REFUSAL OF PLANNING PERMISSION

APPLICATION NO. 2012/0621

Proposal Erection of 1 no. detached dwelling (Outline) (Resubmission)
At Land between 64 and 74 Chapel Street, Hoyland Common, Barnsley, S74 0NW

SITE PLANS

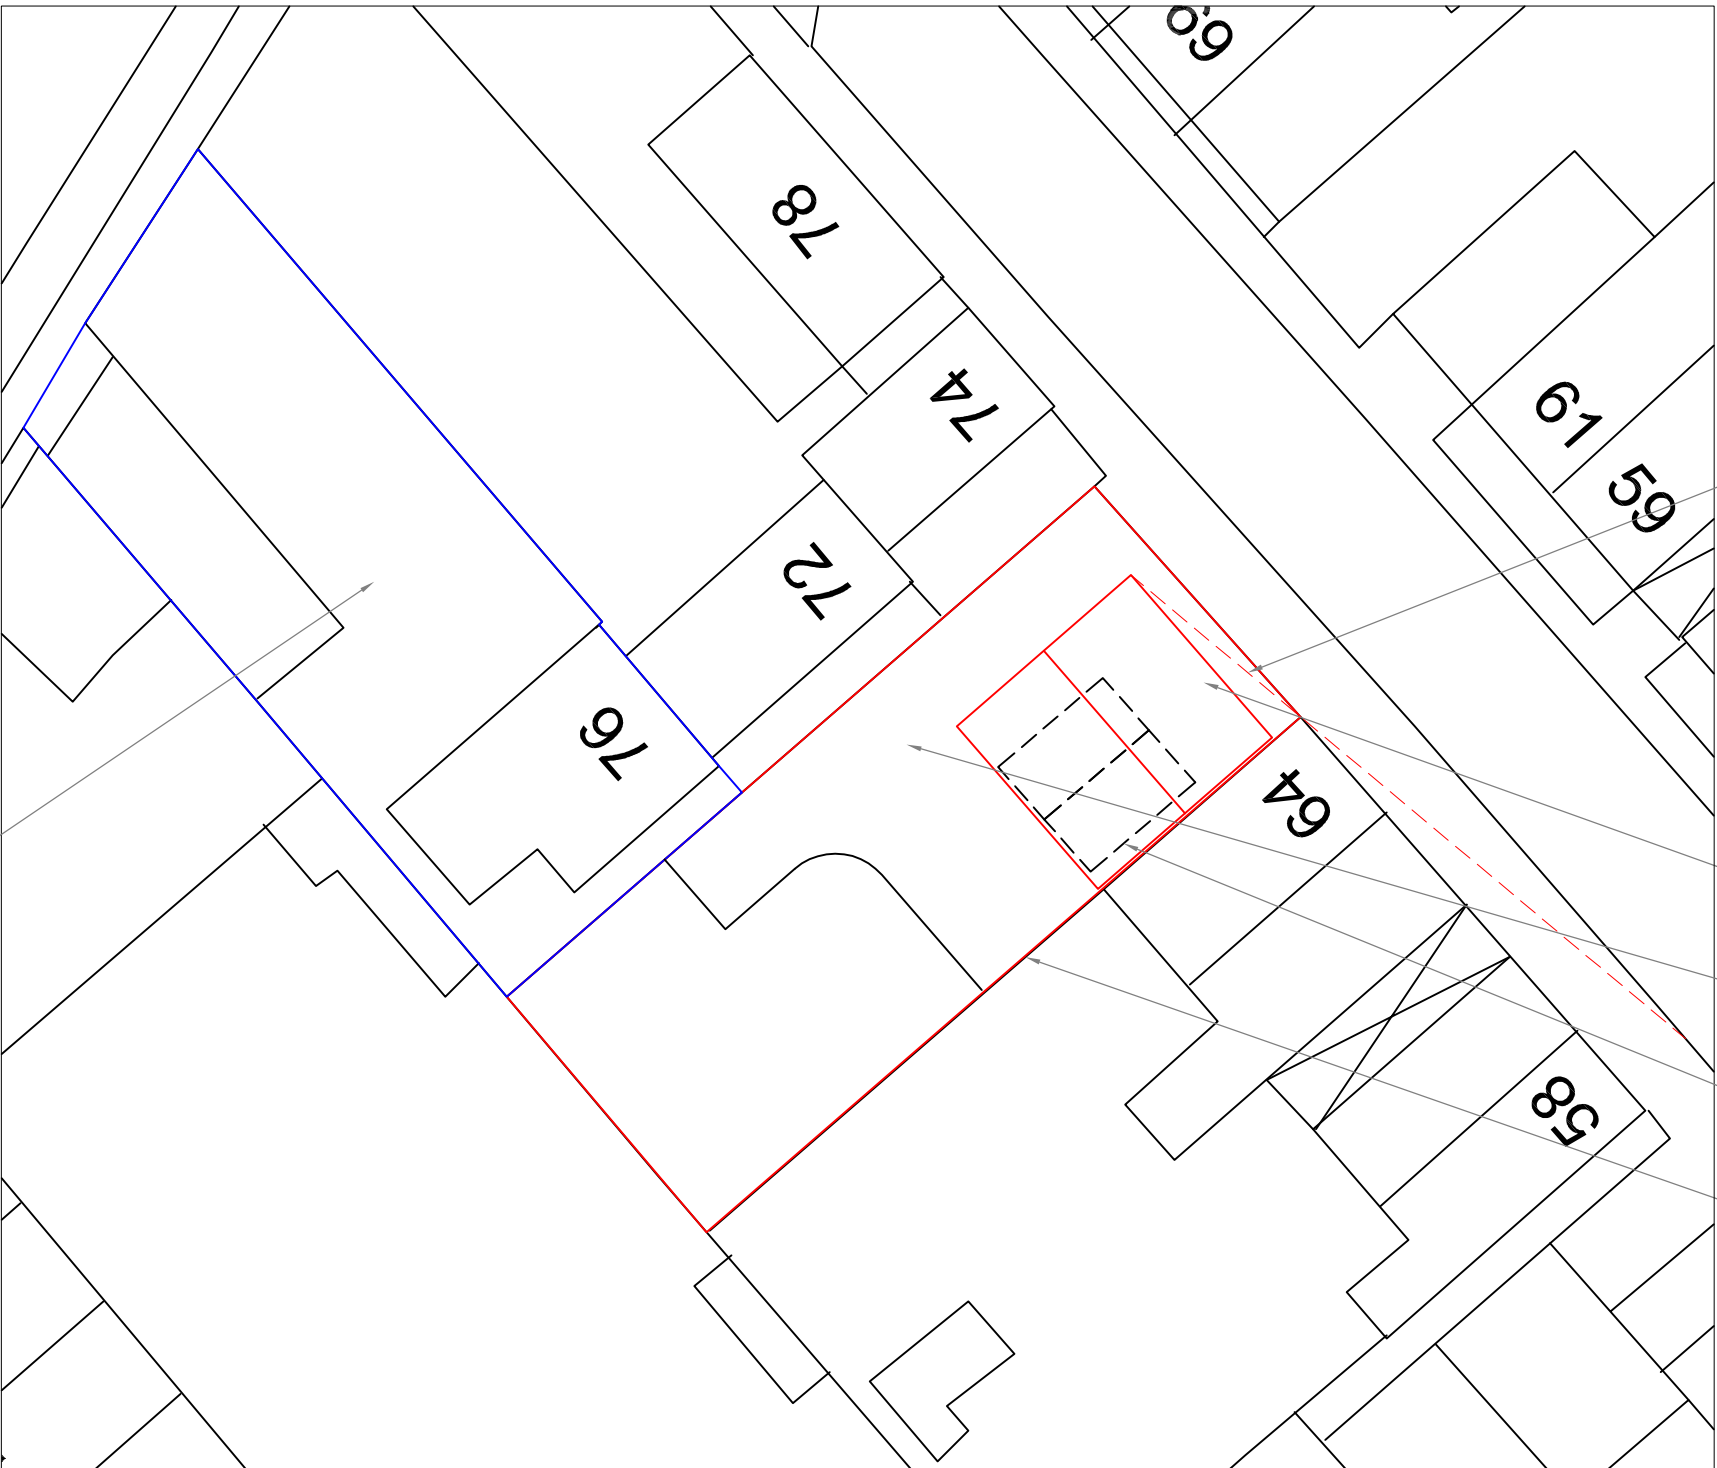
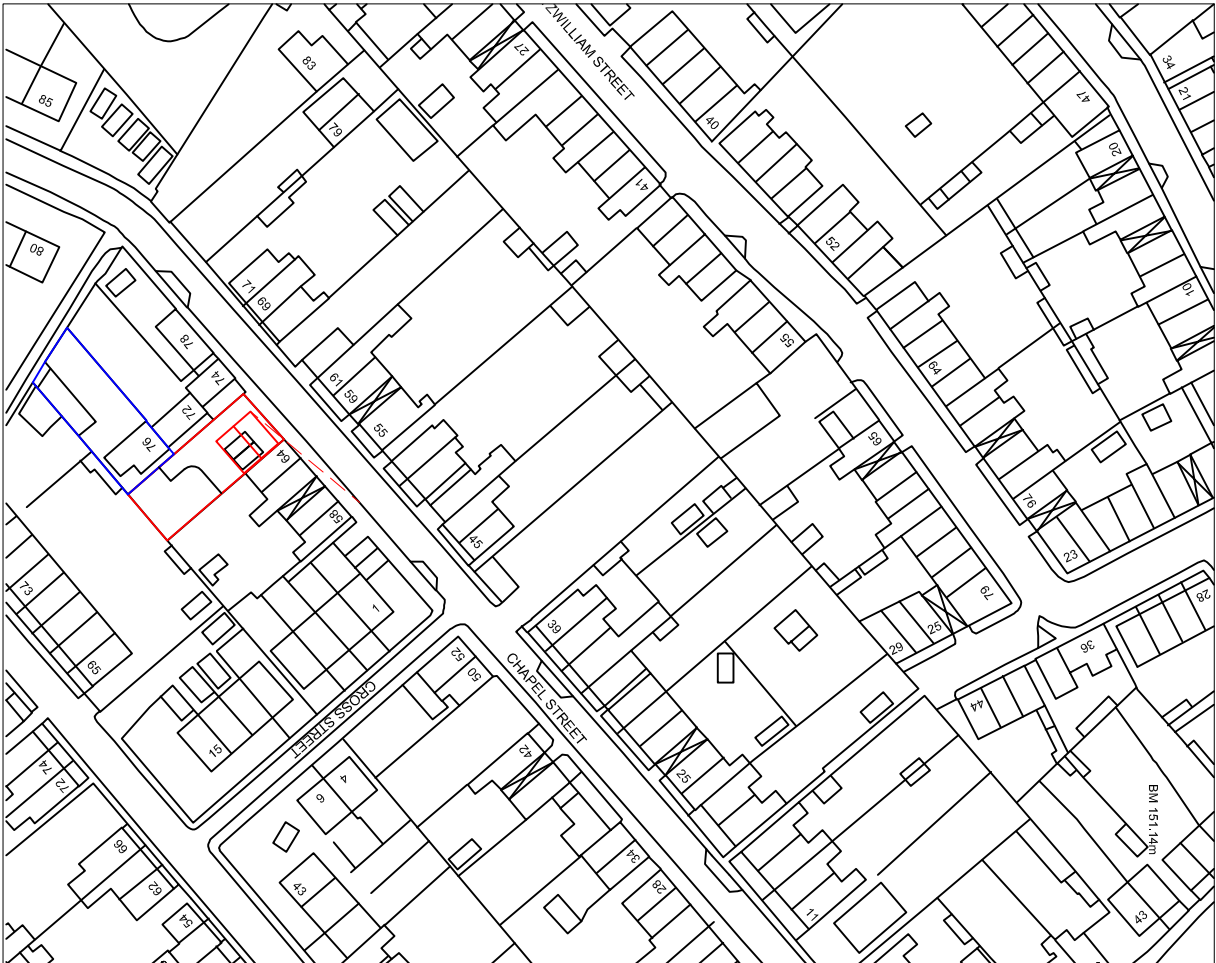
- 1 In the opinion of the Local Planning Authority, the proposed dwelling fails to provide sufficient and suitable overall standards of residential amenity particularly in respect of the levels of mutual privacy. In addition, the position of the adjacent terraced row to the South West of the site would result in an overbearing feature and unreasonable levels of overshadowing to the detriment of future occupants. As such, the proposal would be contrary to saved UDP policies H8A & H8D and SPD 'Designing New Housing Development'.
- 2 In the opinion of the Local Planning Authority the proposed development fails to provide sufficient and suitable parking arrangements and visibility splays to the detriment of pedestrian and highway safety, contrary to Saved UDP policy H8D, Core Strategy Policies CSP 26 and CSP 29 and SPD 'Designing New Housing Development'.
